Submission for: Narrabri Underground Mine Stage 3 Extension Project

# Crown Lands

Figure ES-6

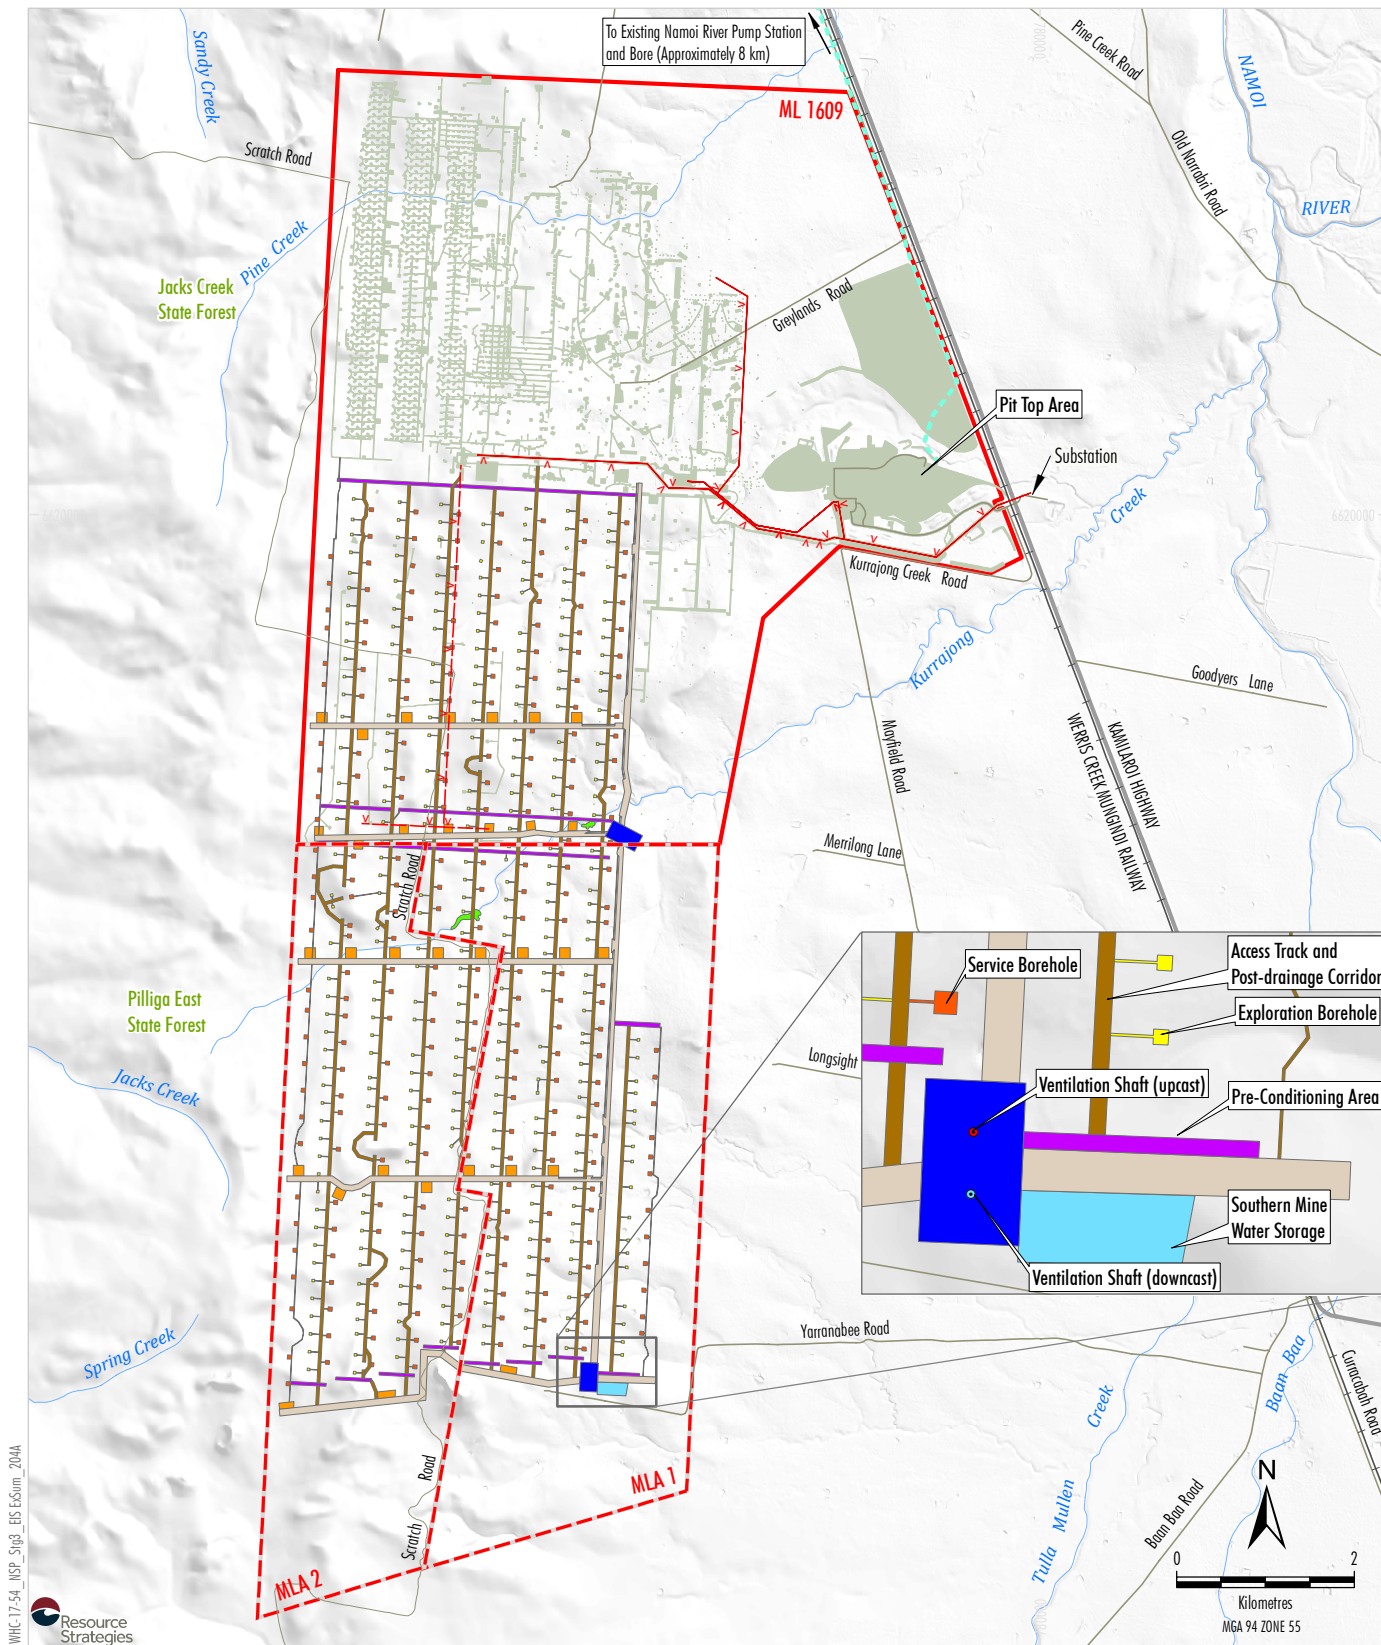
The indicative location provided of some surface infrastructure is upon or within close vicinity of these roads.

It is recommended that the proponent ensures that a comprehensive Crown Land conveyancing search, available through the Department, has been completed. Any and all impacted Crown land or Crown roads must have that impact authorised via the Department, or alternate authorising instrument identified prior to the works being commenced.
